Doreen Christ - Re: 50 Industrial Wy., BP#2014-01701 plan review comments

GRANT HAYS ASSOCIATES
FIRST FLOOR
FACILITY CODE
COMPLIANCE PLAN
DRAWING TITLE
SCALE 1/16" = 1'-0"
DATE 7/25/2014
DRAWN BY SAM/MPH
JOB NO. 140560
DRAWING NO.
AC-1

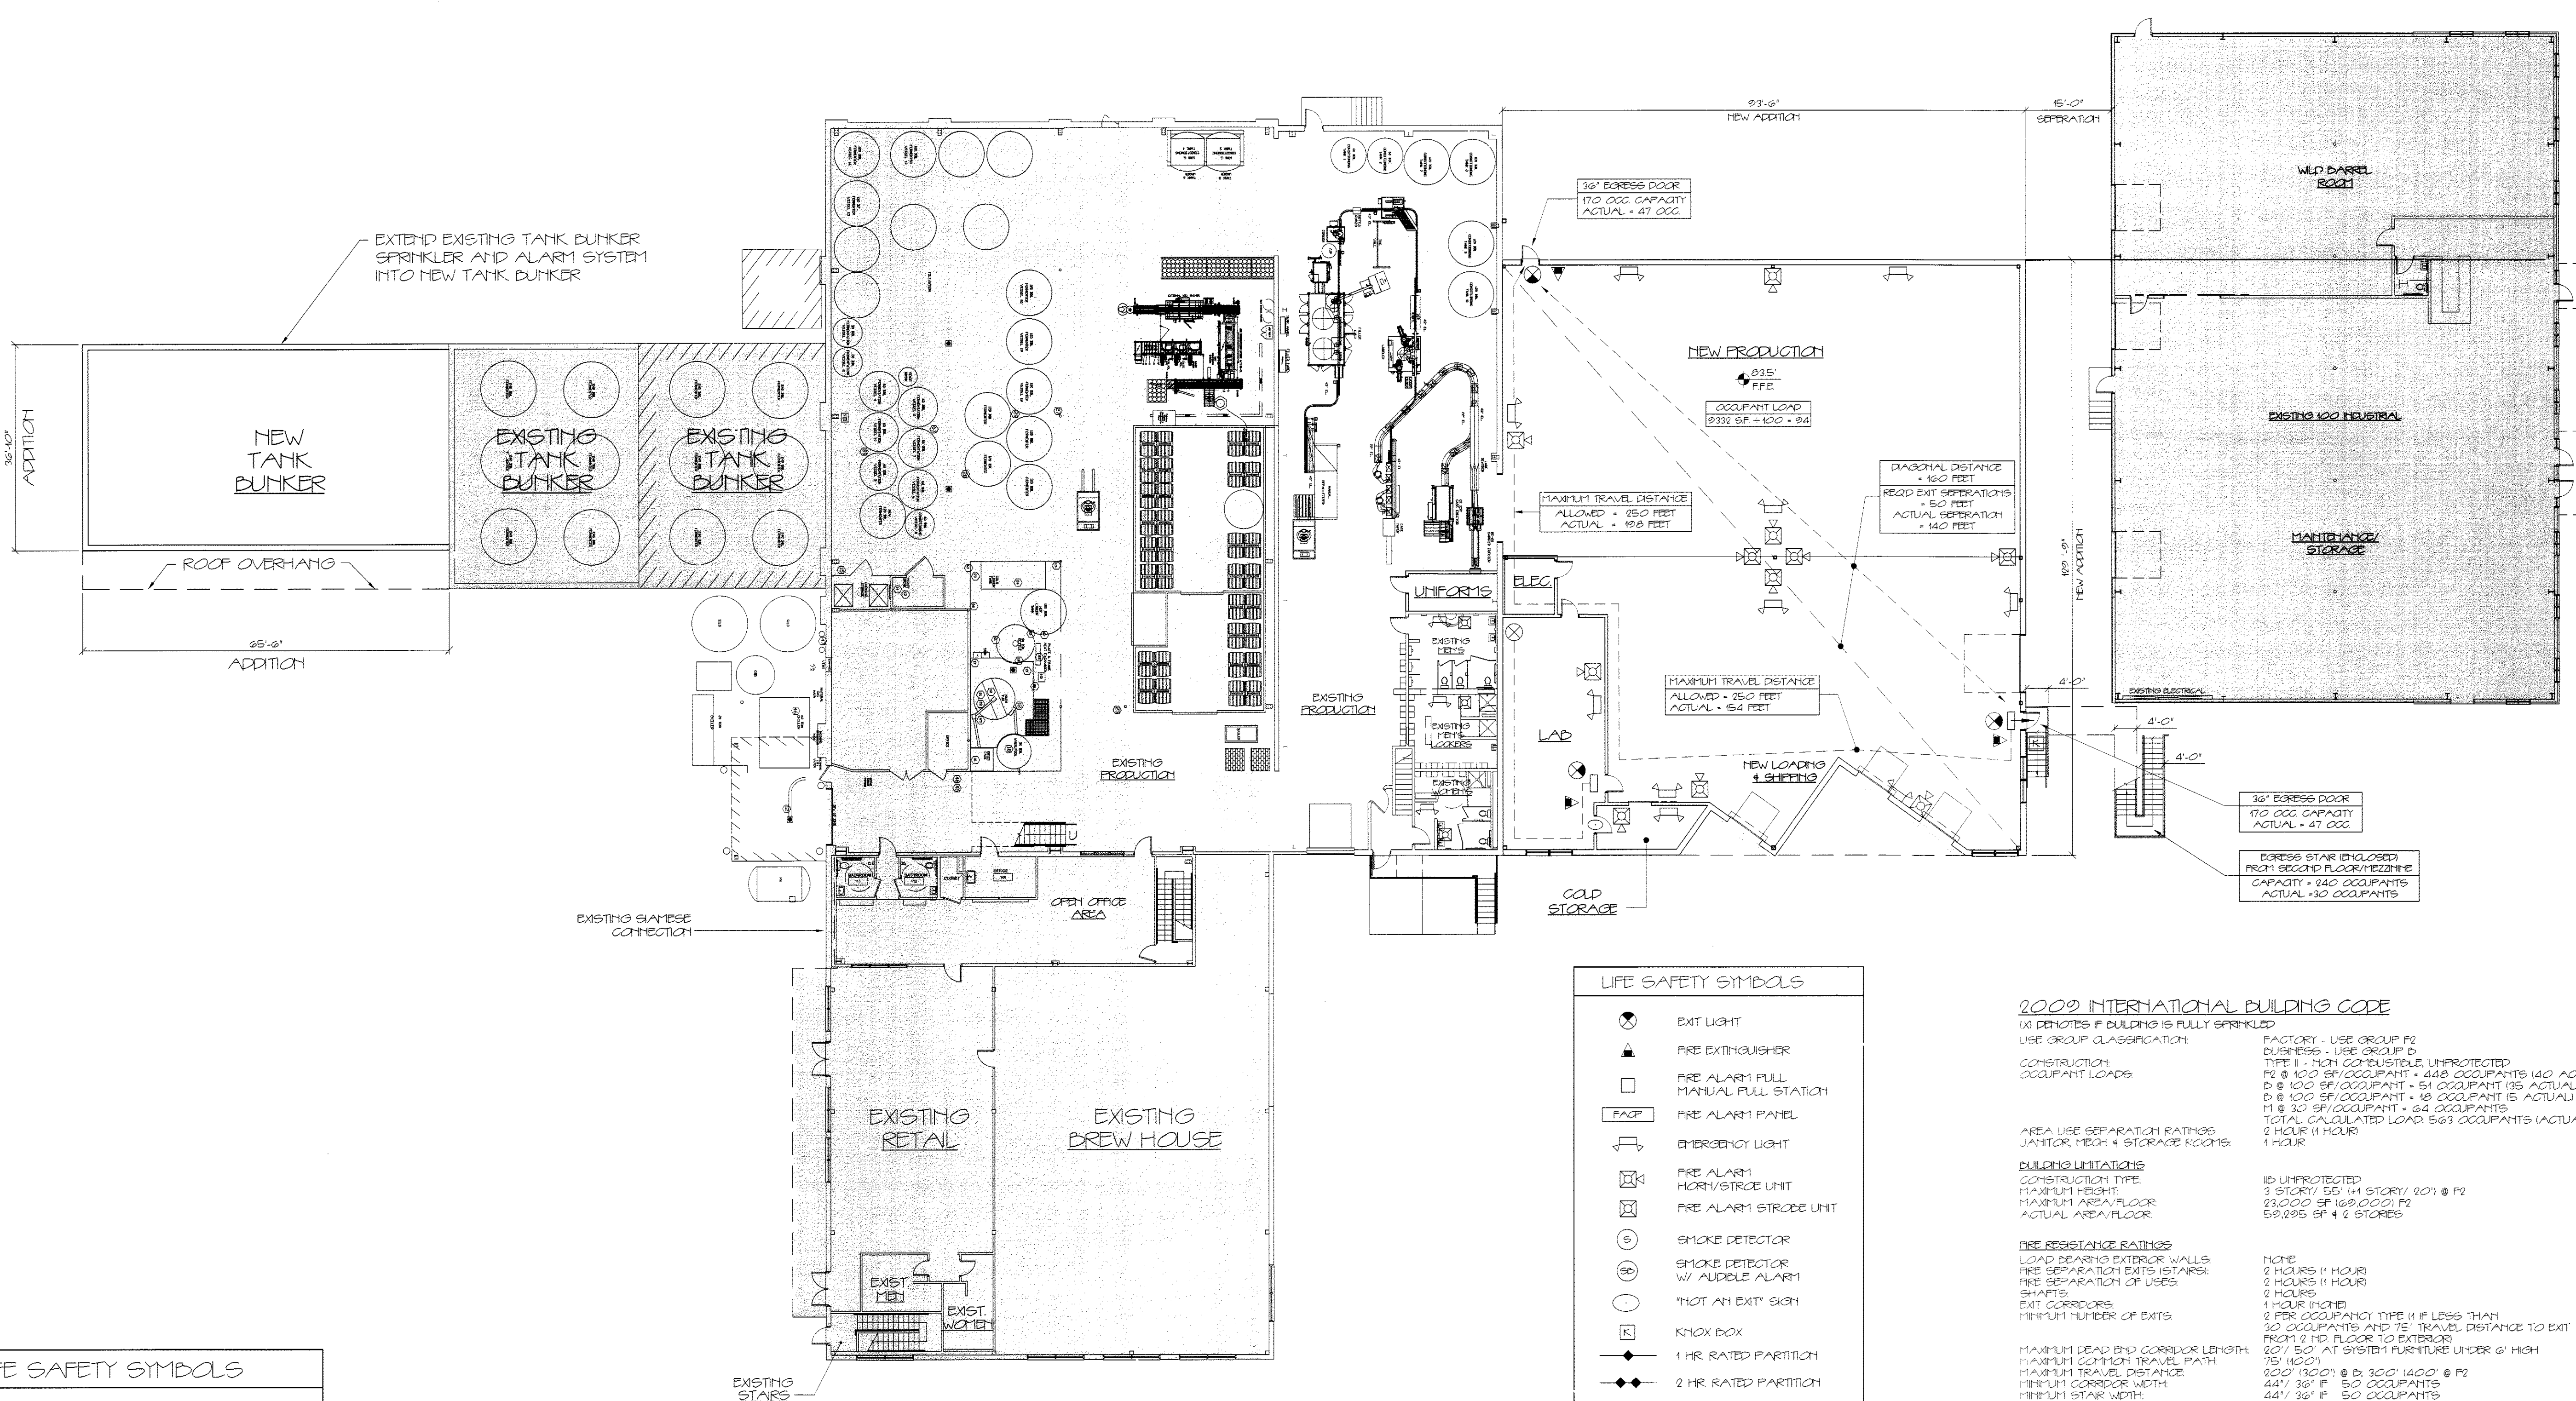
I had a chance to start the review today, and can't seem to find the code analysis and a life safety plan. Hopefully Mike Hays can clarify this. Also, the application did not detail specifically this project, ie. location, size, phase (?). The set of drawings included AC-1 and AC-2, which are the Architectural Code sheets for the first and second floor levels depicting the entire Plant. They also identify the new additions for this phase with the relevant code criteria. There are full 2012 NFPA 101 and 2009 IBC code summaries on these sheets also. I've attached a set for your convenience in case the original submission did not include them.

See the answers to the code questions below in RED. I will let Paul/Rick Meek answer the scoping/phasing questions.

SITE PLAN - PHASE 1

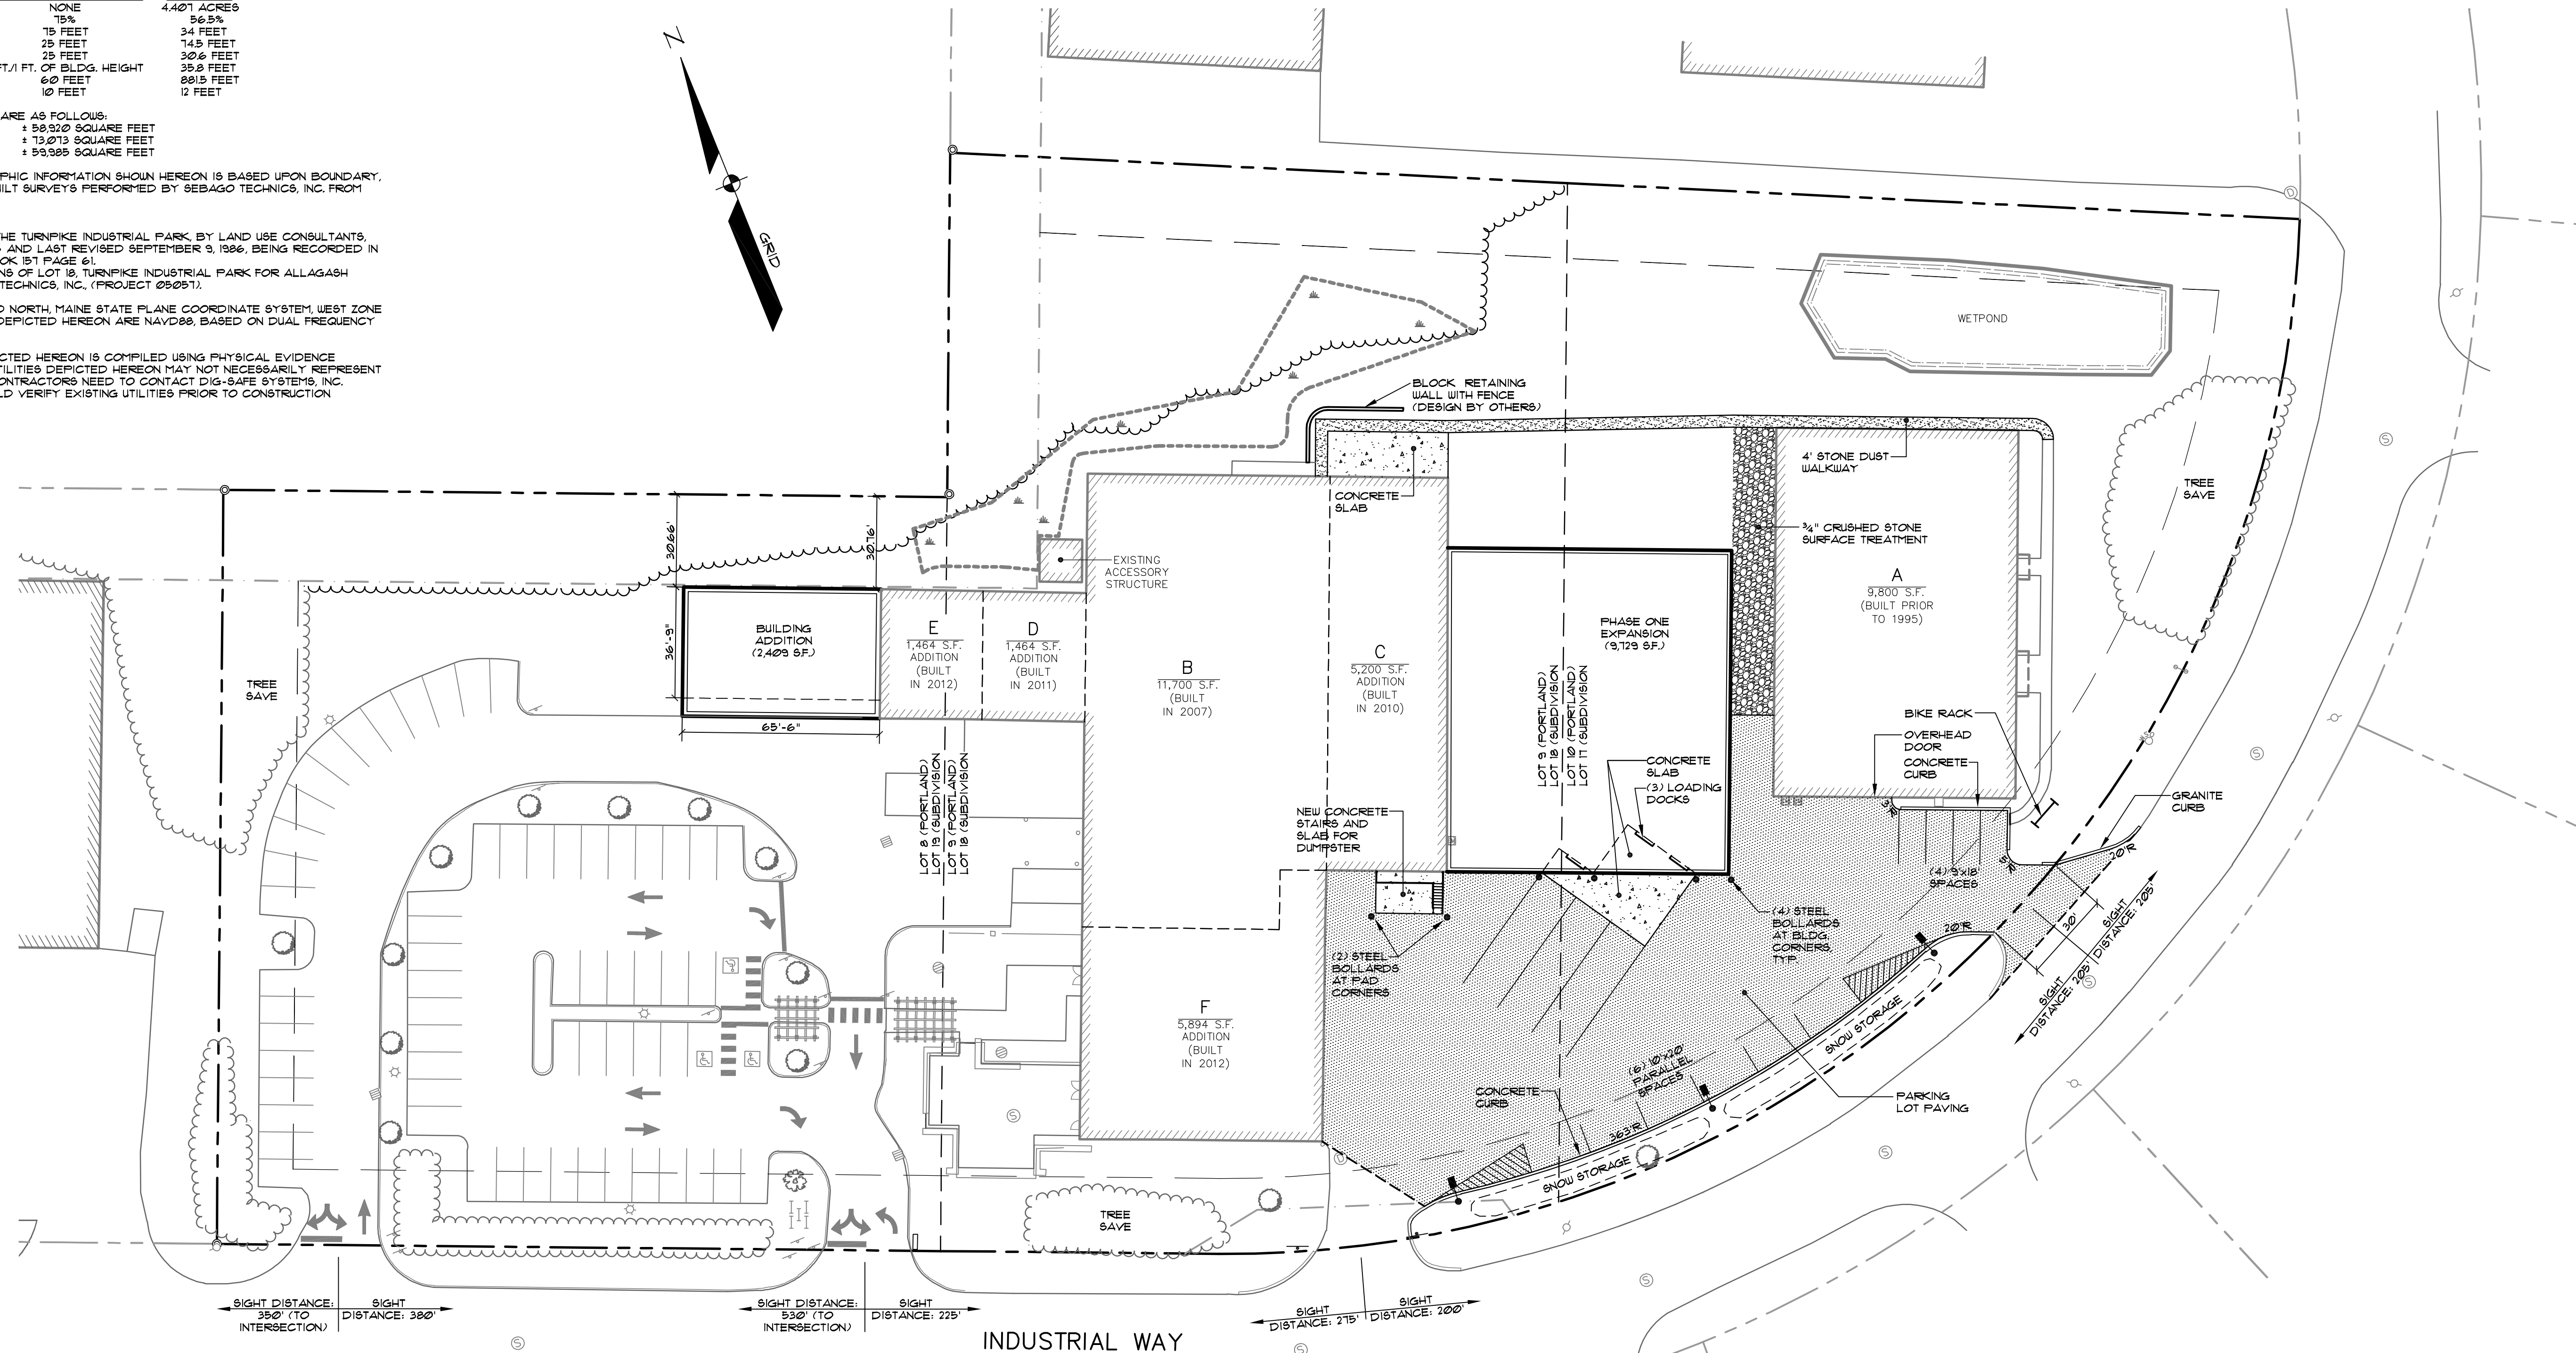
With the volume of work at Allagash it is essential that a key plan identify this. The site plan shows two additions, the previously permitted "bunker" addition, and the Phase 1, but this should be clearly stated in the project description or scope of work. This will assist our administrative staff at the intake as well.
